TfNSW Reference: SYD24-01344/01
DPHI Reference: SSD-63168959

**EXHIBITION OF EIS FOR NEXTDC S5 DATA CENTRE AND INNOVATION HUB
269 LANE COVE ROAD, MACQUARIE PARK**

Tab A: TfNSW comments and recommended conditions

SECTION 1 ROAD 6 TYPICAL SECTION
SCALE 1:100

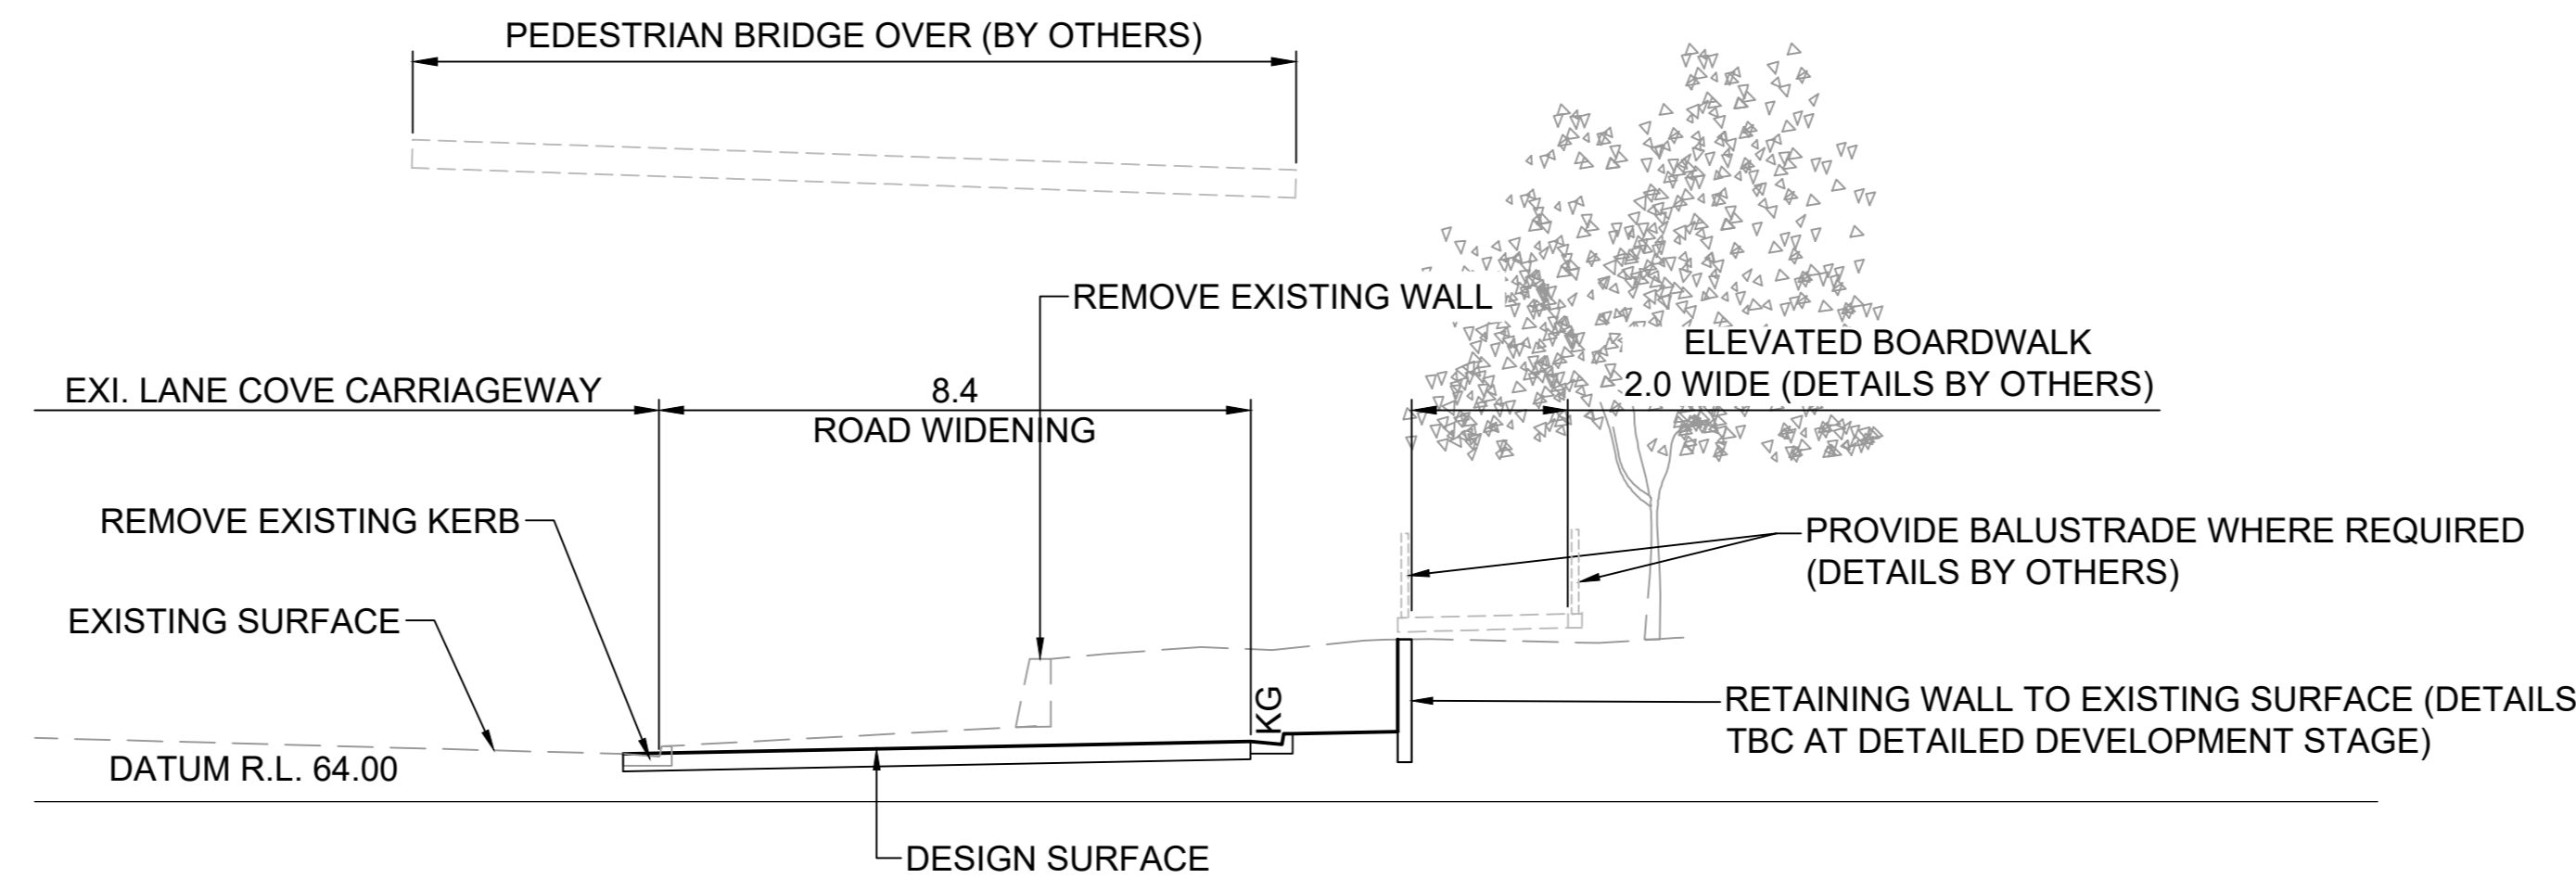
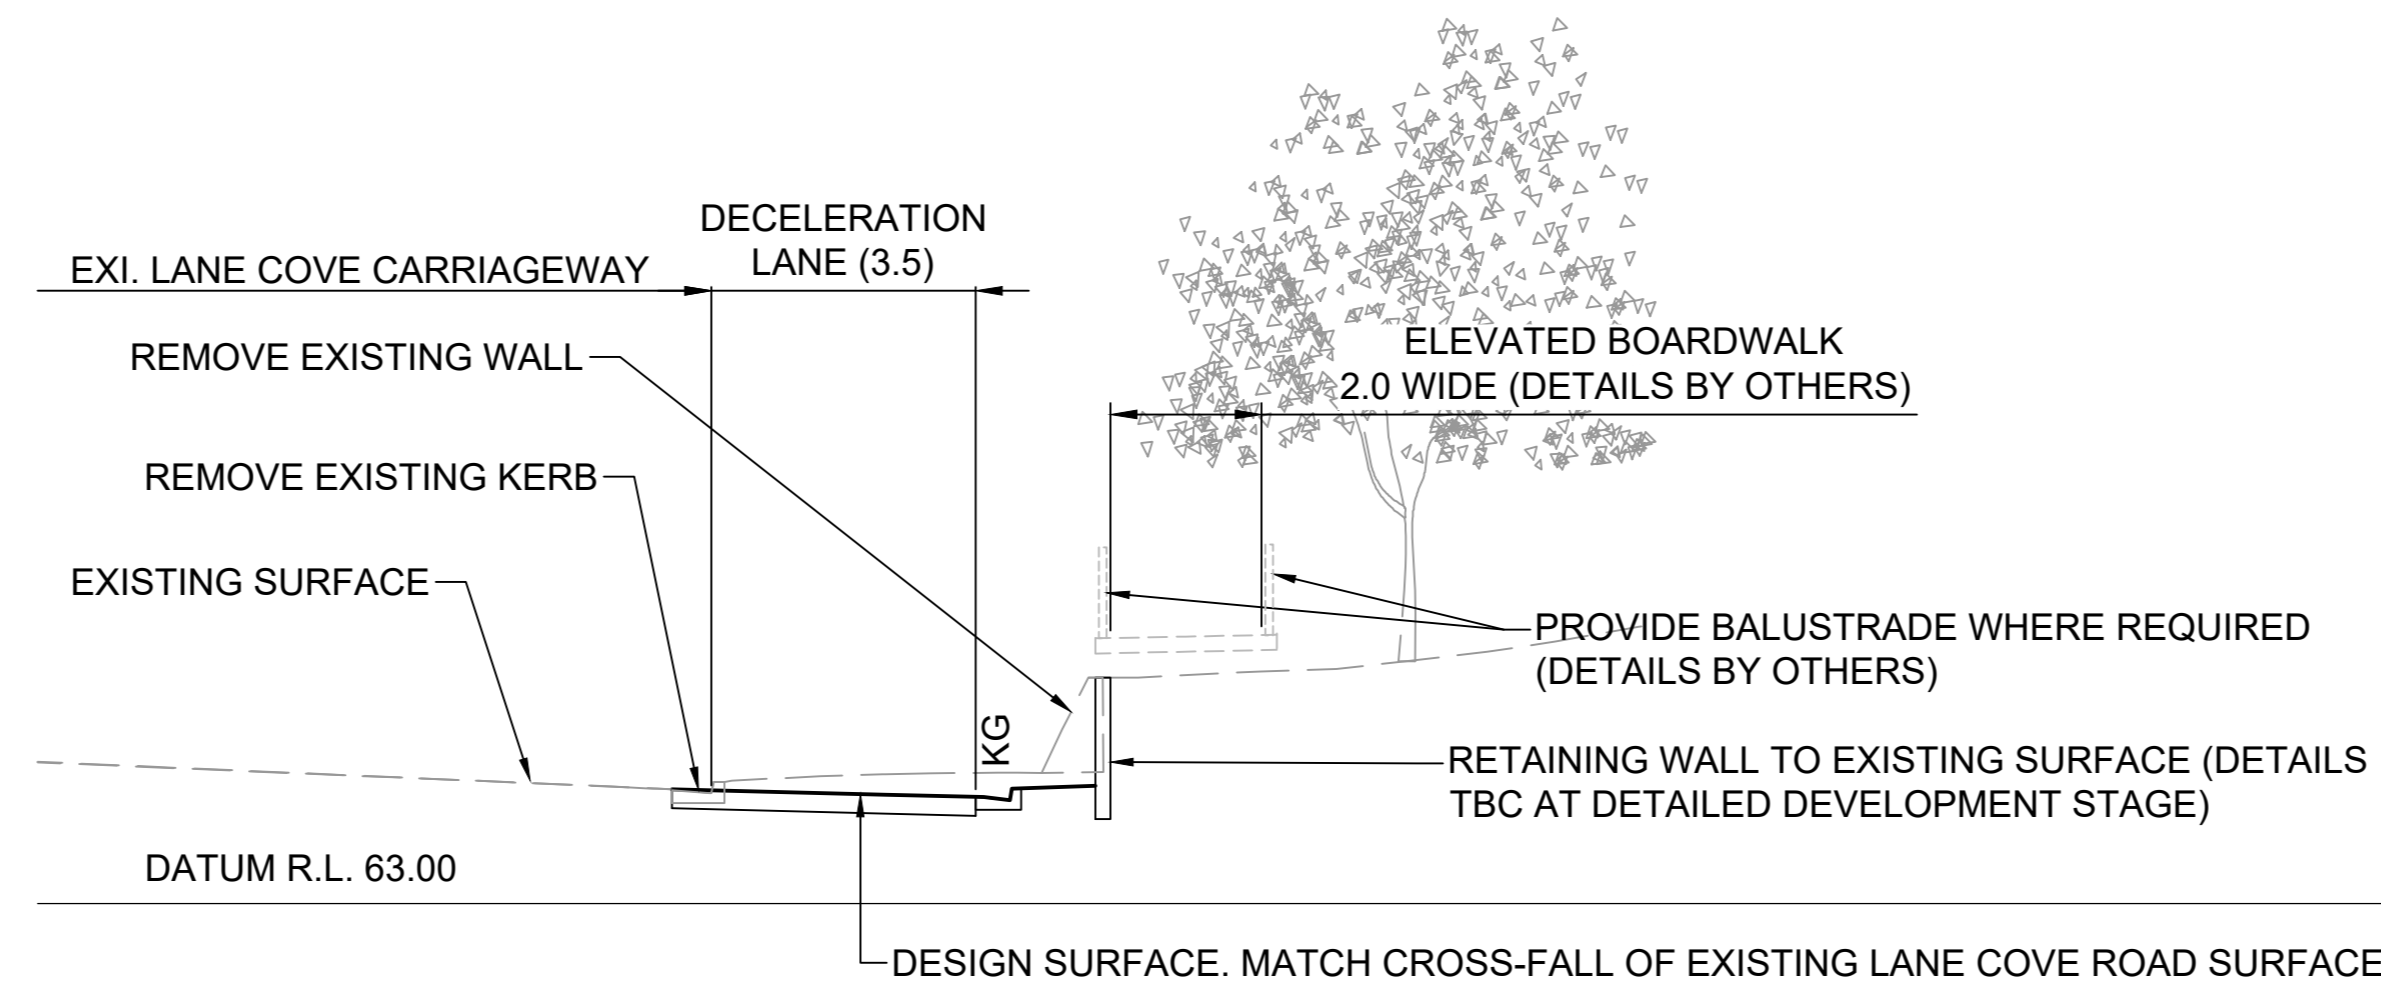
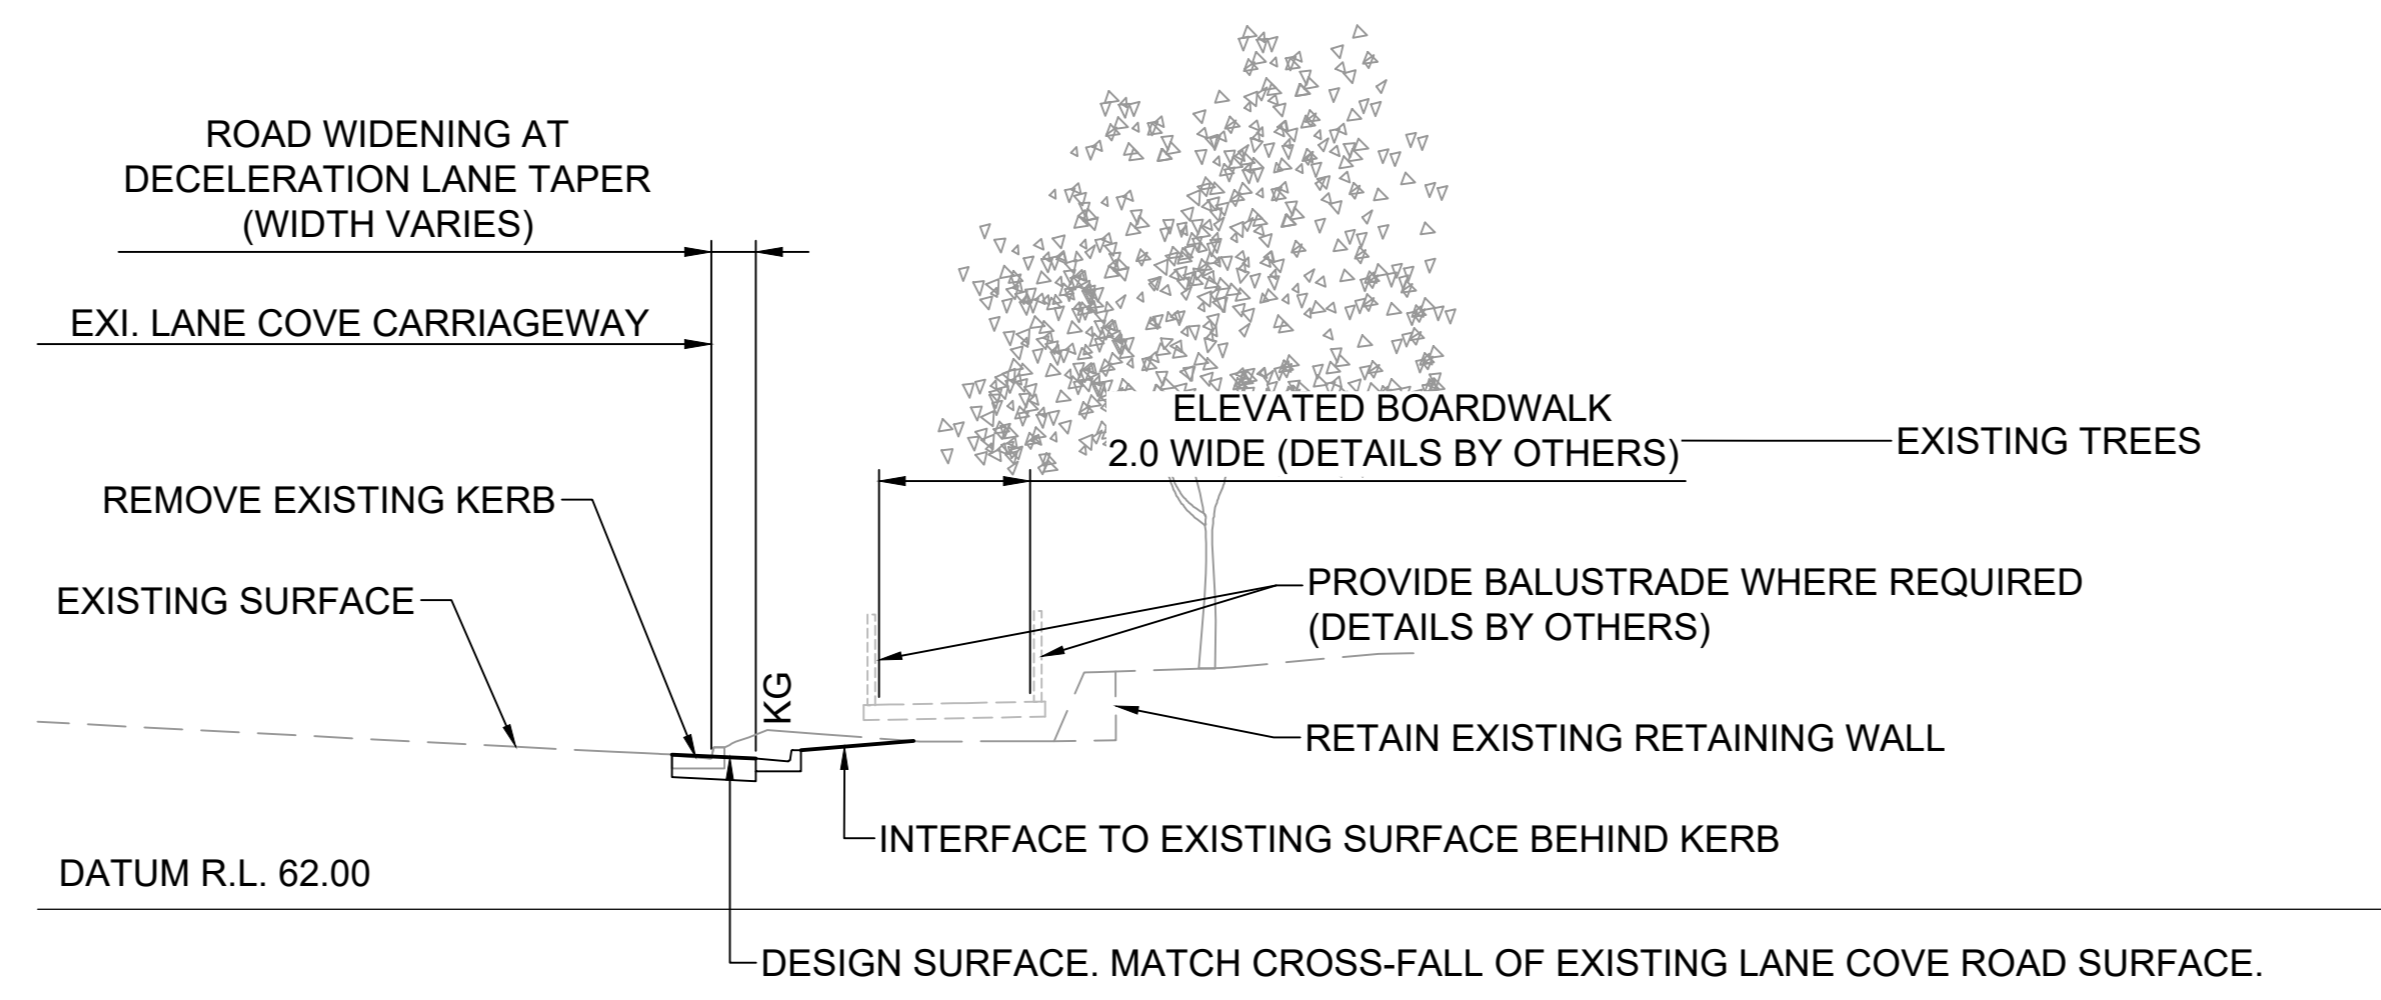
3. Site Design	<u>Comment:</u> Consideration should be given to the Macquarie Park Innovation Precinct Urban Design Framework which is understood to be currently under assessment by DPHI. Depending on the final approved road layout, building structures and setbacks should not preclude required roads, such as proposed Road 6, from being built by others in the future.
